A66 NORTHERN TRANS-PENNINE PROJECT DCO

IP A R Leeming Ref 20031946

PRINCIPAL AREAS OF DISAGREEMENT AND COMMON GROUND as at 5 December 2022

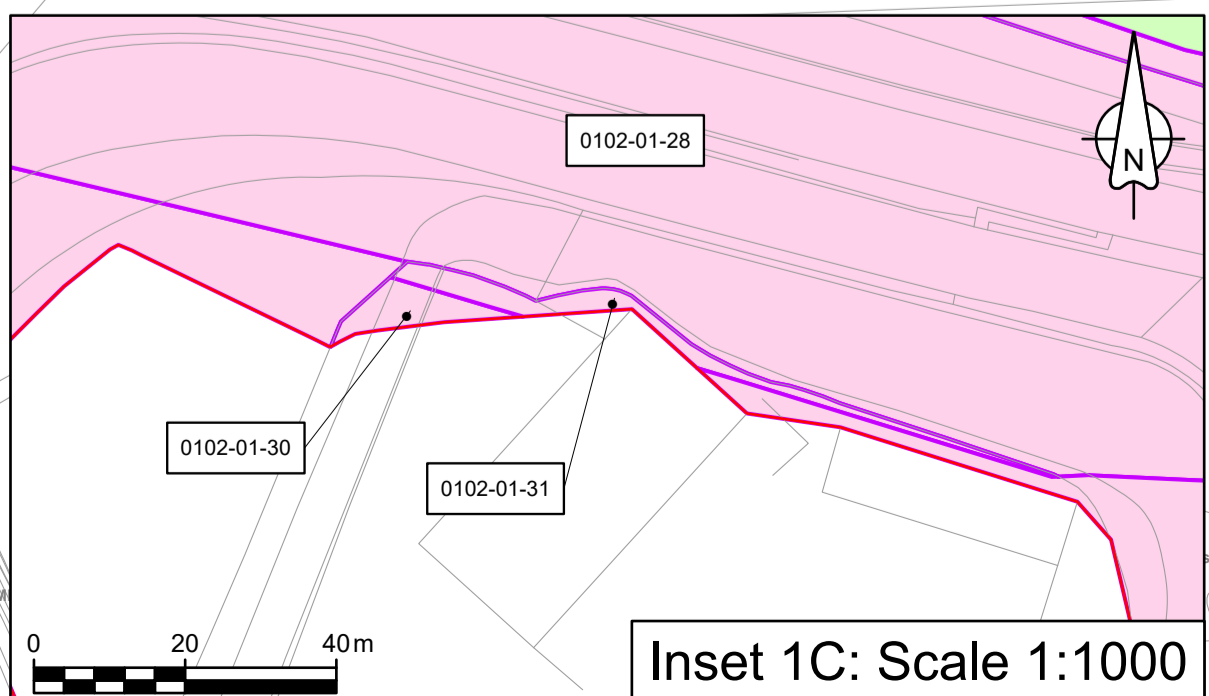
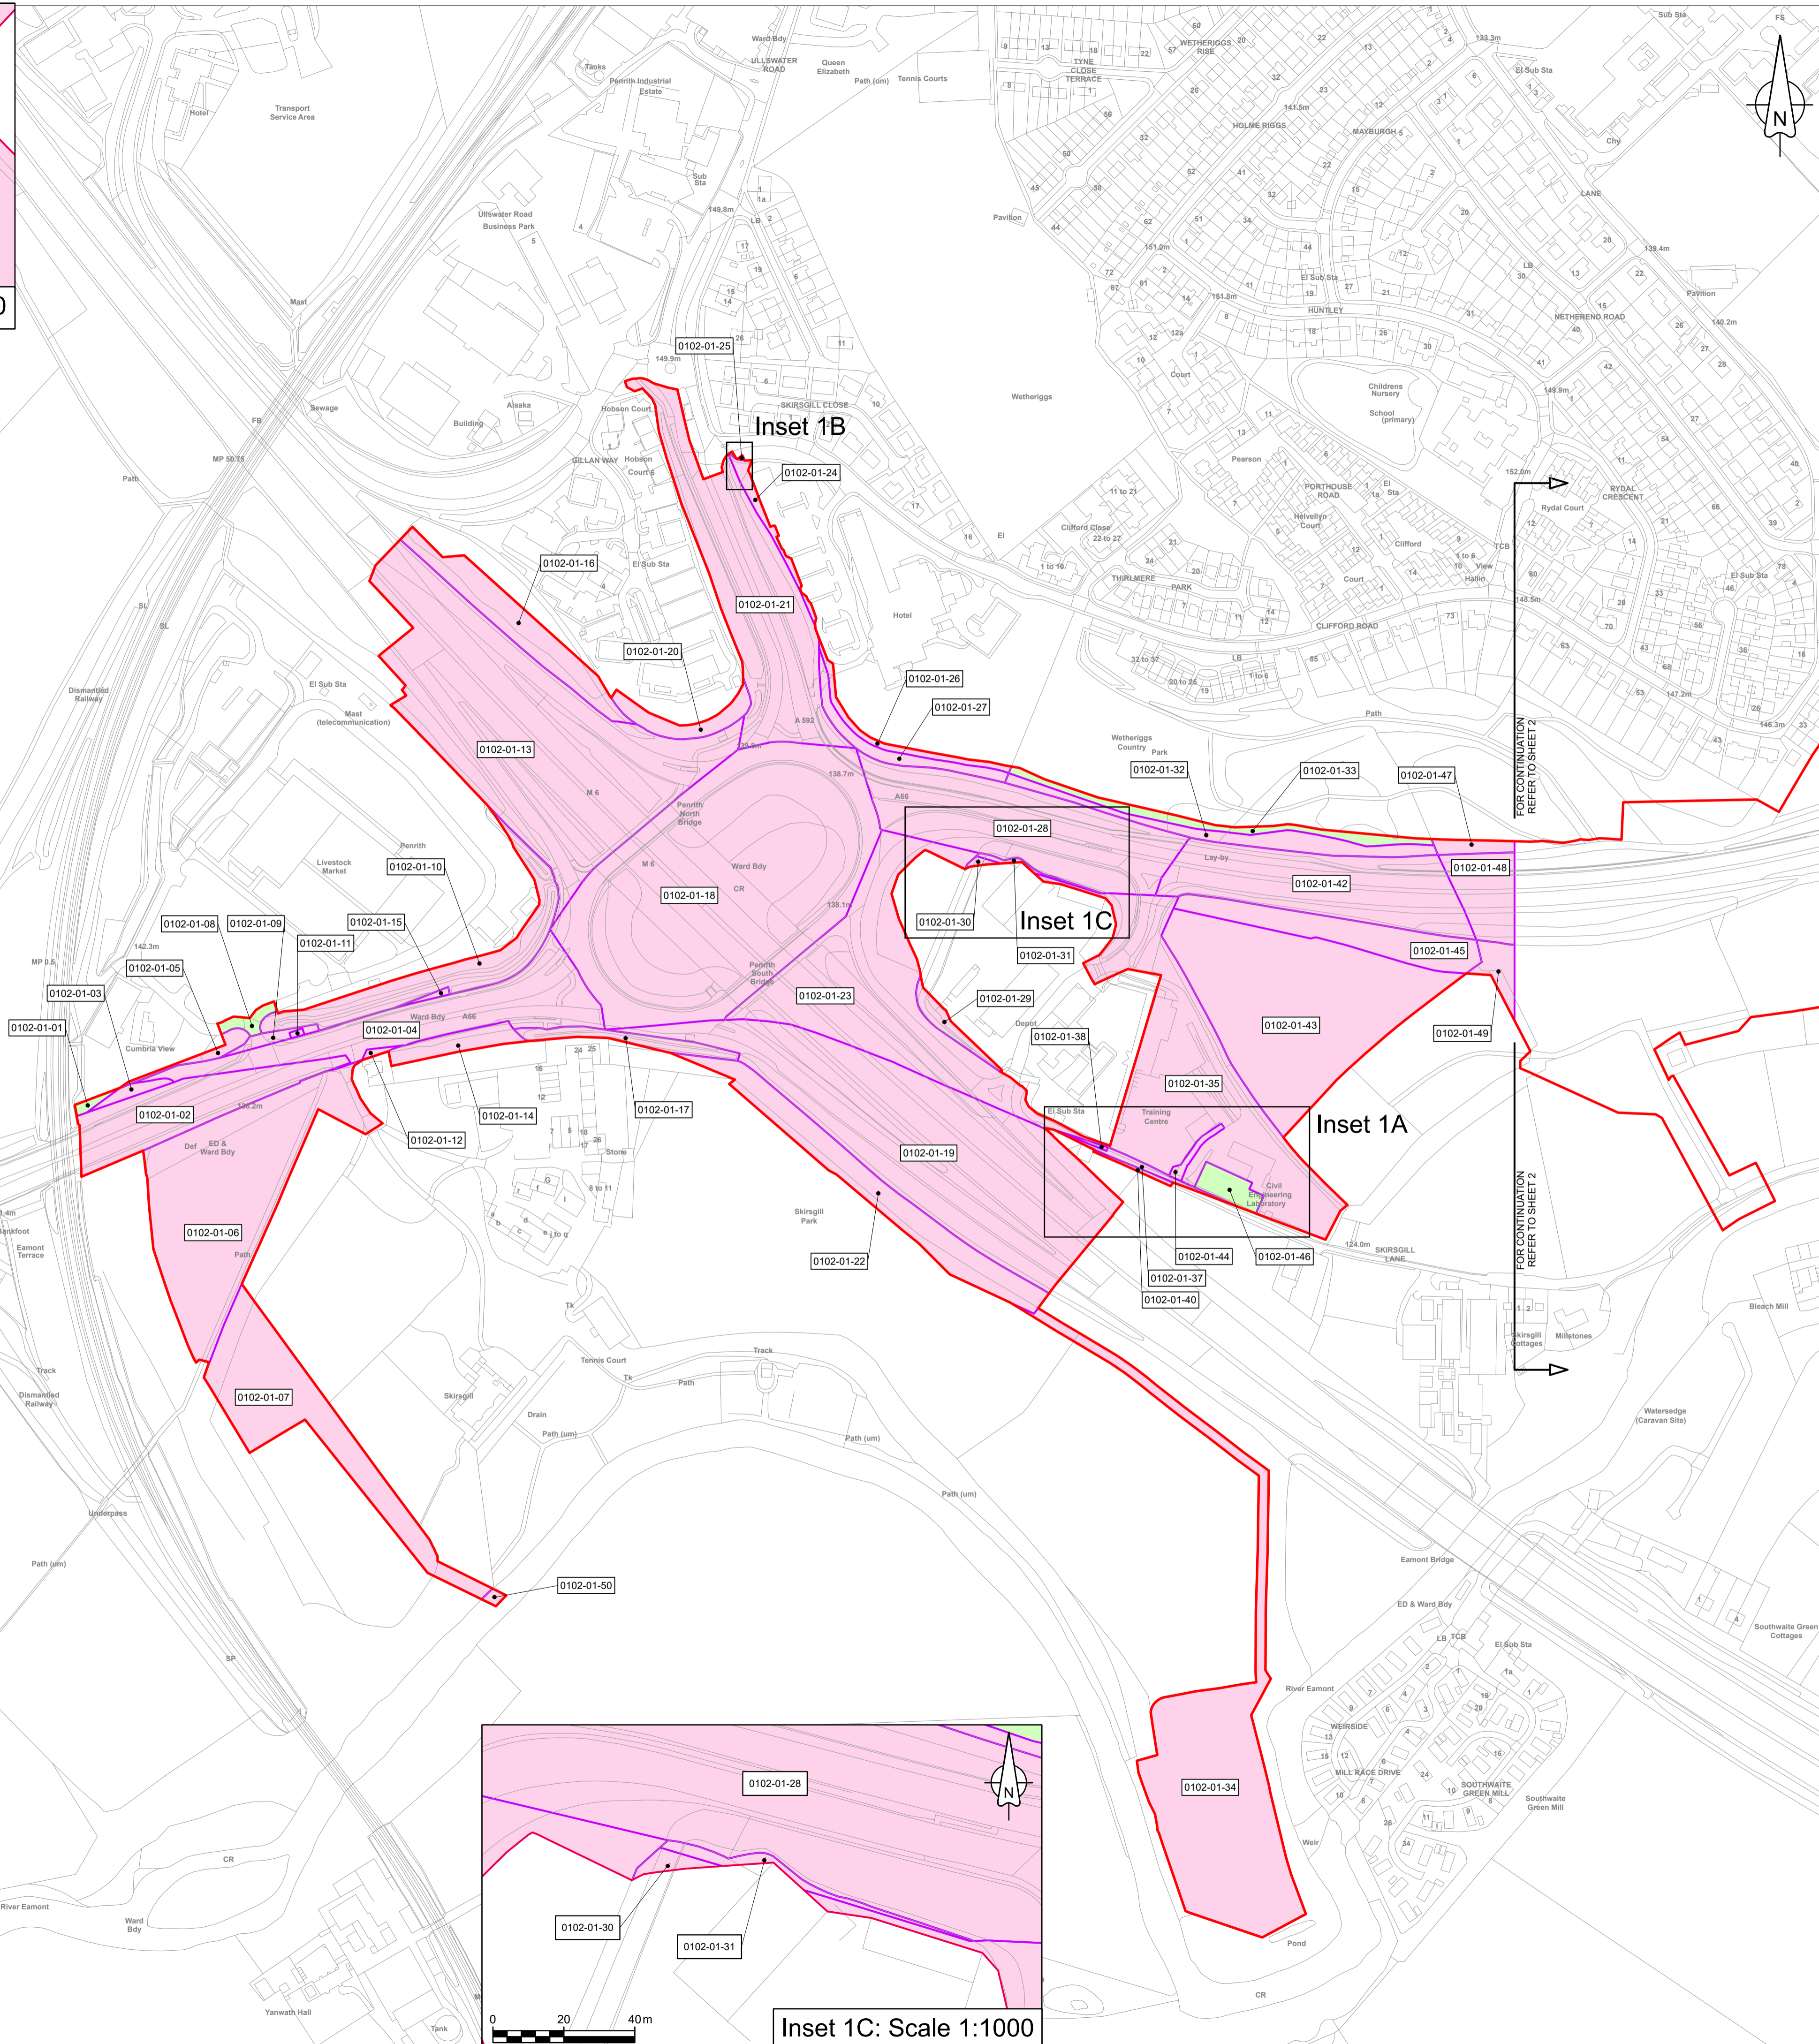
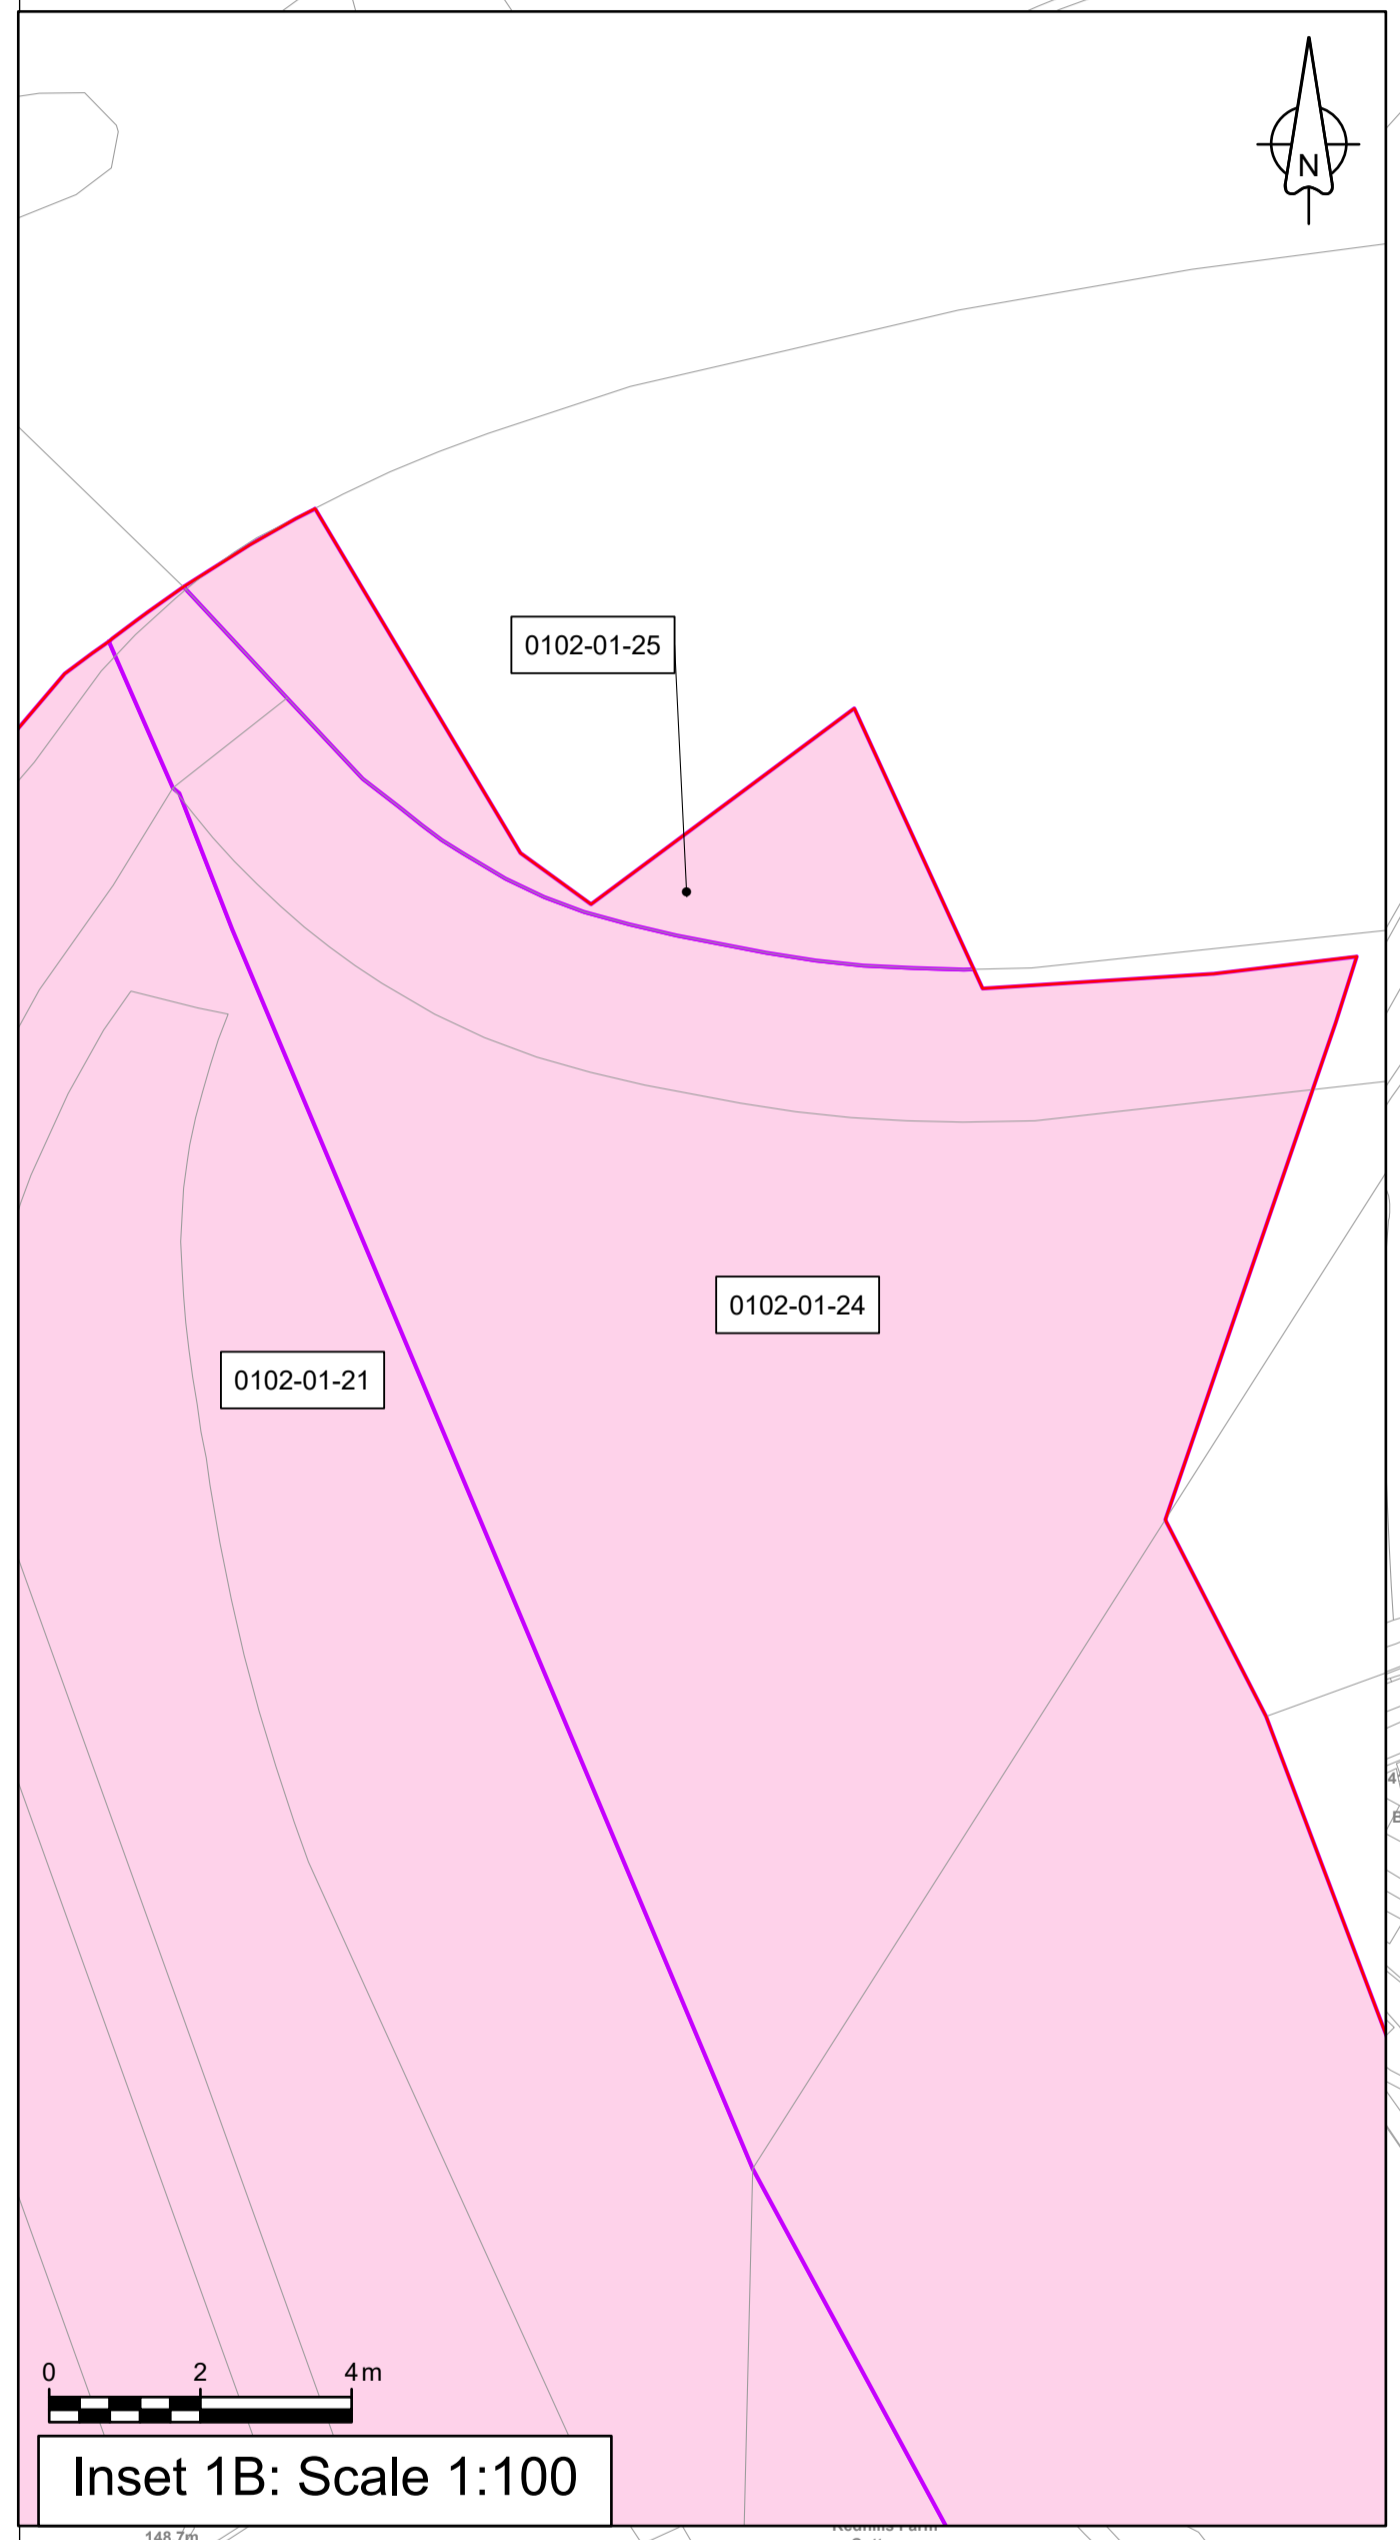
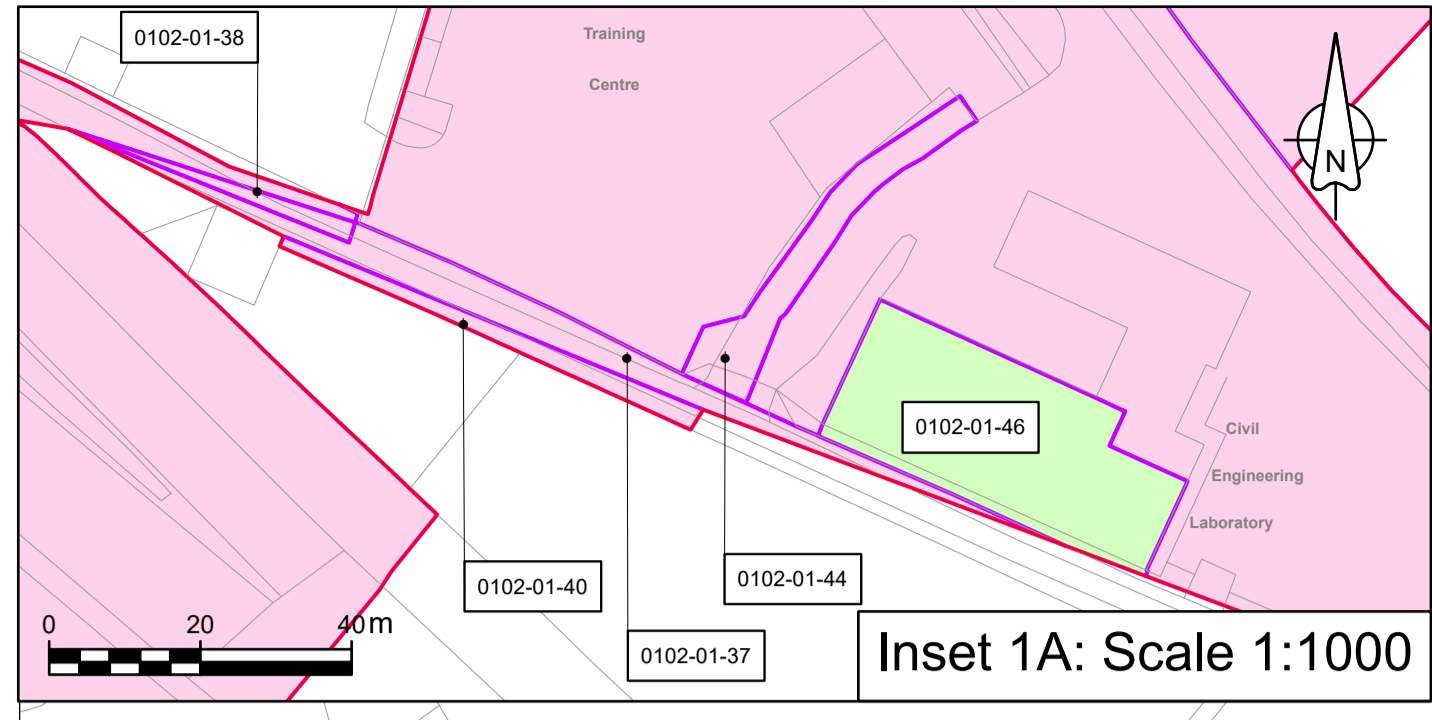
Plot No.	Consultee/IP	Summary of Consultee Comments	National Highways Response	Current Position
0102-01-01	A Leeming	Temporary Licence Restoration details required	None	IP awaiting information.
0102-01-03	A Leeming	None No objection to acquisition	None required.	No further action required
0102-01-06	A Leeming	Proposed attenuation pond construction with associated drainage. IP considers. <ol style="list-style-type: none"> No justification in engineering terms has been provided for this pond. Entrance to Skirsgill Park and Business Park does not need to be permanently acquired. Access for construction and subsequent maintenance 	If speed limit is adopted between M6 Junction 40 and the existing railway bridge there would be no requirement for this pond. Investigation and redesign is ongoing.	Response from National Highways (NH) awaited.

<p>can be given from A66 direct if needed.</p> <p>4. If pond justified the construction, it would be desirable for this to be designed as a more natural looking pond, without use of concrete paving, utilitarian fencing and signage etc, given it will not be publicly accessible.</p> <p>5. The existing 24" drain and outfall to the R Eamont should be sufficient to drain the relatively small area of additional hard service proposed.</p>		
0102-01-07 0102-01-50	A Leeming	<p>IP objects to permanent acquisition of this plot</p> <p>Permanent acquisition of this area is not needed.</p> <p>If works are required an easement for drainage would be sufficient to install/alter drainage of the proposed pond at 0102-01-06</p>	As 0102-01-06 above.	Response from NH awaited
0102-01-14	A Leeming	<p>No principal objection</p> <p>Details of accommodation works required.</p>	None to date.	Response from NH awaited
